CDS is requesting comments on the following Conditional Use Permit application: CU-26-00001 Jentges.

SUBJECT: WDFW COMMENTS ON JENTGES CONDITIONAL USE PERMIT (CU-26-00001)

TO: All Staff
FROM: Public Works Plan Review Team
DATE: April 30, 2026
SUBJECT: CU-26-00001 Jentges

**Figure 1.** This image shows Mercer Creek flowing north to south near the eastern boundary of the project area and two flood channels west of the main channel.

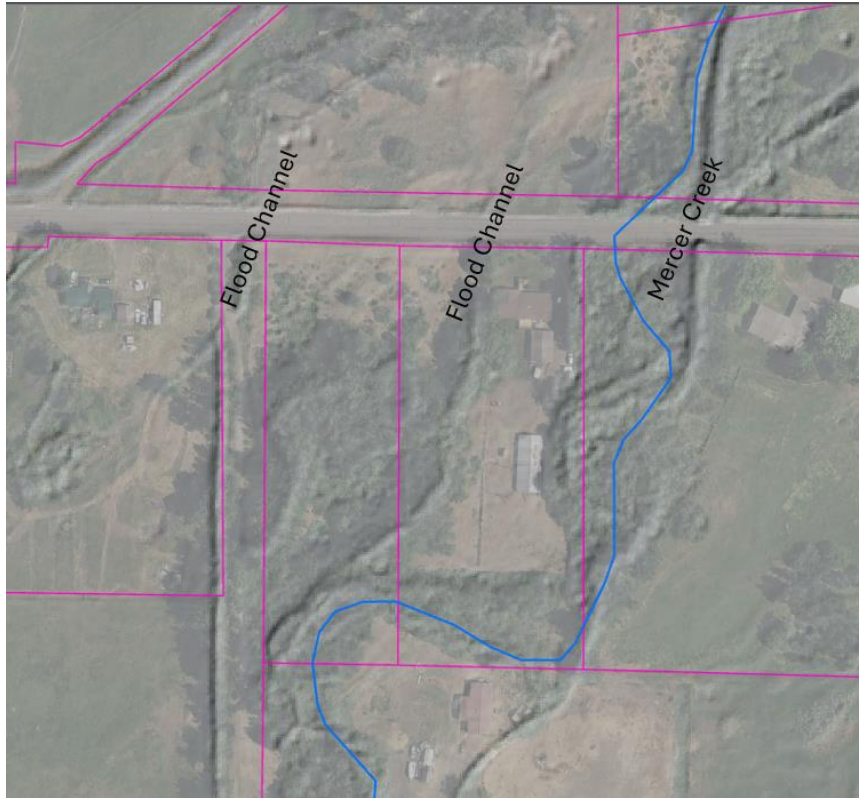
While we appreciate the critical areas map that was provided with the online materials, there does not seem to be a detailed critical areas report associated with this application to evaluate potential impacts to critical areas. Mercer Creek is a fish bearing stream and a distributary stream of Wilson Creek on the Wilson-Naneum Alluvial Fan. Native fish and freshwater mussels are present throughout Mercer Creek. The site plans provided with the application accurately show the main channel of Mercer Creek as "Stream", but they do not identify the two nearby high flow or flood relief channels that also convey flood waters (see Figure 1).

The application materials reference removal of underbrush to increase usable land, but few details exist as to where this will occur relative to the Riparian Management Zone associated with Mercer Creek in the County's Critical Areas Ordinance (KCC 17A.04.030). We understand that some structures already exist on site and that some new uses are proposed. What is not clear is how the critical areas have been identified and how they will be protected with approval of this conditional use permit.

To further understand the impacts to critical areas, particularly Fish and Wildlife Habitat Conservation Areas, WDFW requests a site visit with the applicant and the County. A mitigation, monitoring, and restoration plan should be prepared in consultation with WDFW as a condition of approval.

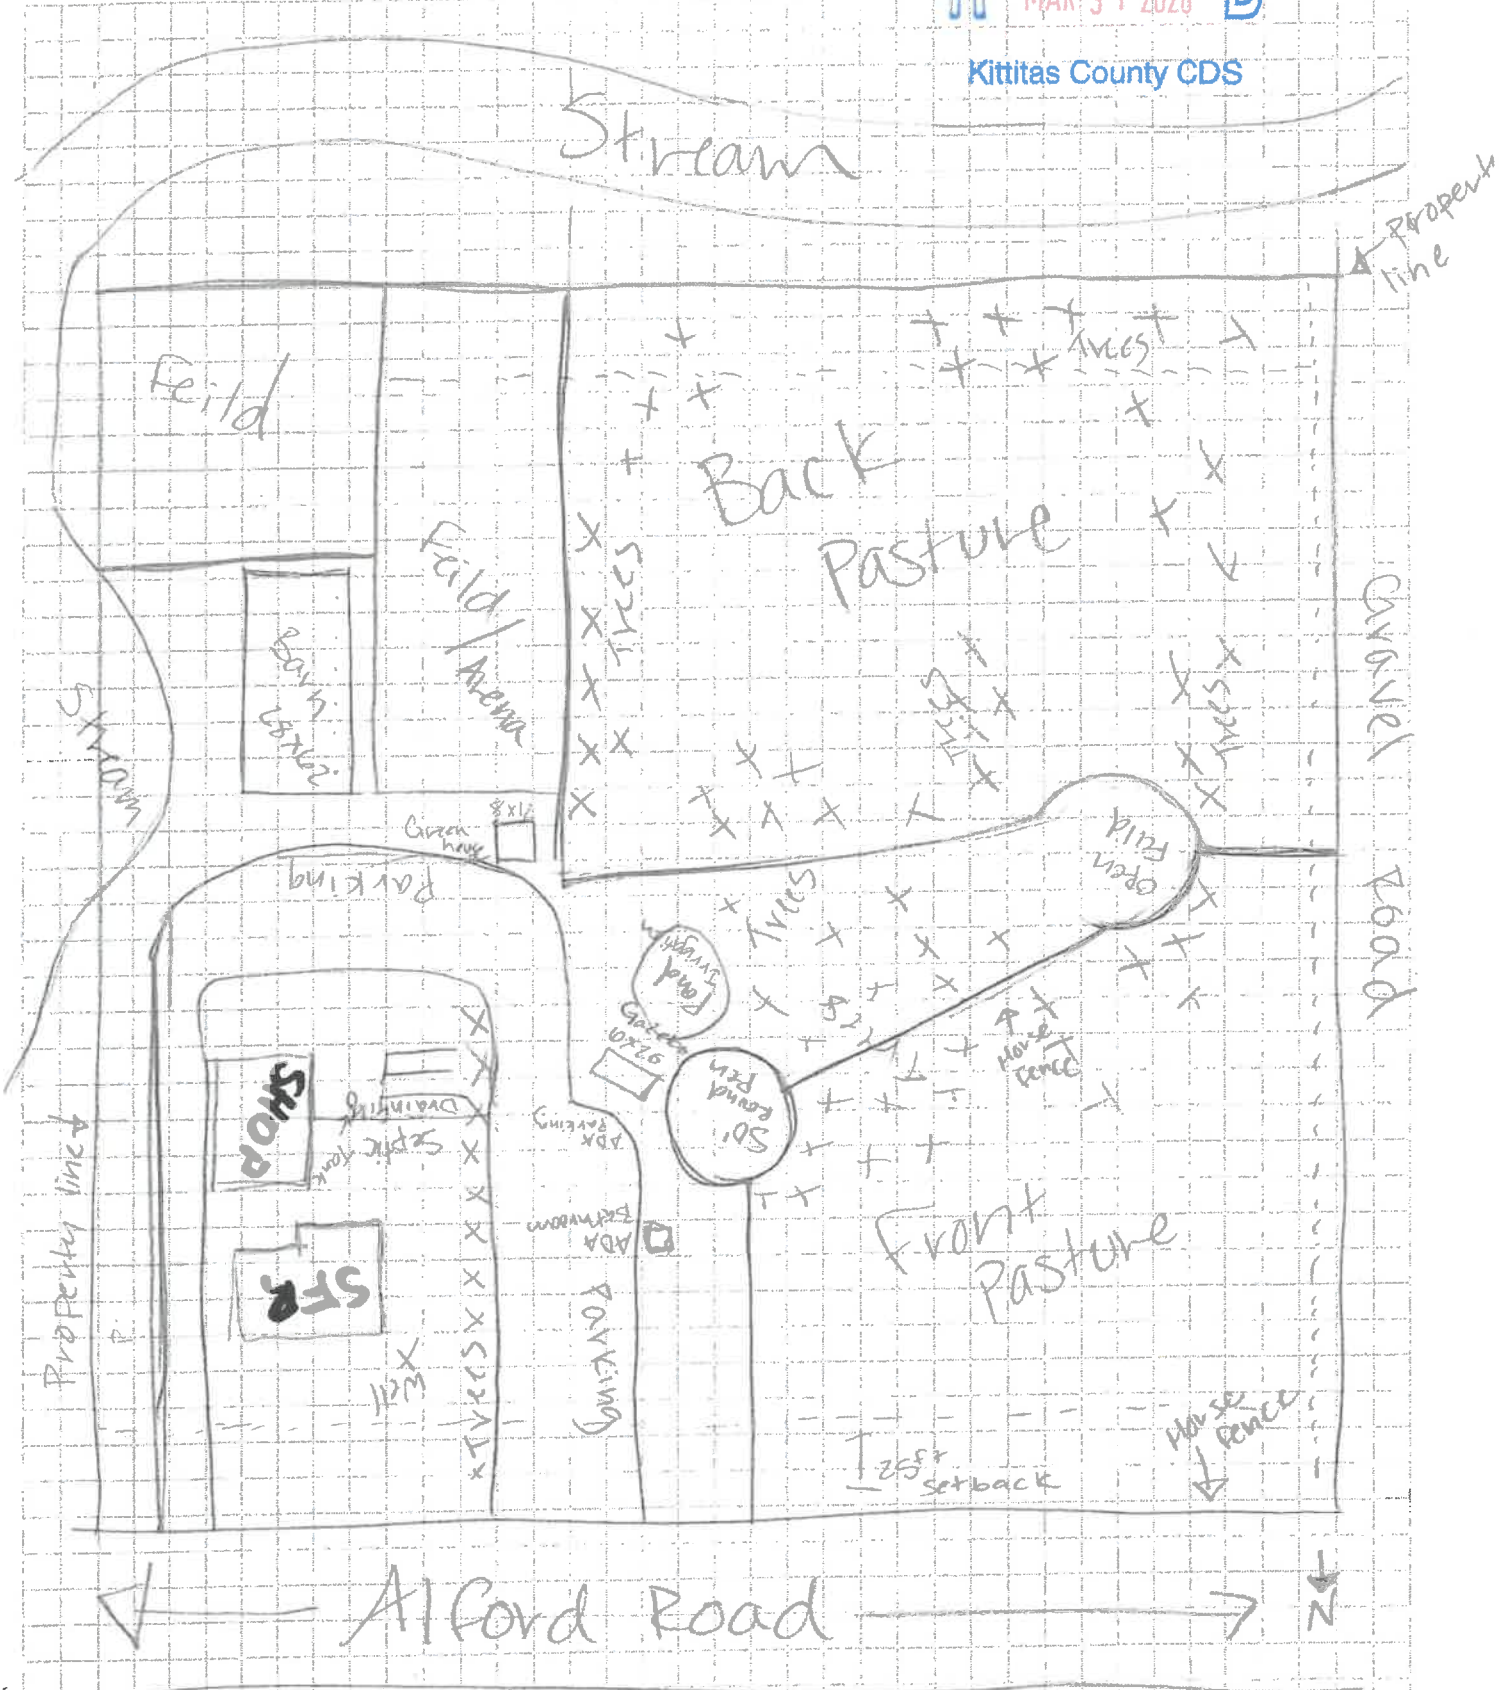
Daily or peak trips entering/exiting a 50 mph two lane road are unknown based on the available application materials. The CU application shows two driveways that are 100' apart on Allford Road, one existing and one new. Our driveway to Alford Rd. serves two homes and is within 250' feet of the recently installed driveway at the Applicant's property.

Our home is less than 100' from the proposed open-air event area, horse arena and the "riding academy", and pasture uses that presumably will be for on-saddle riding by guests. We understand that the yoga meadow activities will be directed by a nonresident instructor/practitioner.

We are also within 225' of the "Barn" described in the Narrative as animal occupied. We are concerned that this 2,000-sf building may be used in the future for large group occupancy unless conditioned otherwise by the CU Permit.

Parking for 25 cars is apparently proposed. This would indicate at least 25 and perhaps as many as 75 people could be on the Applicant's property at any given time.
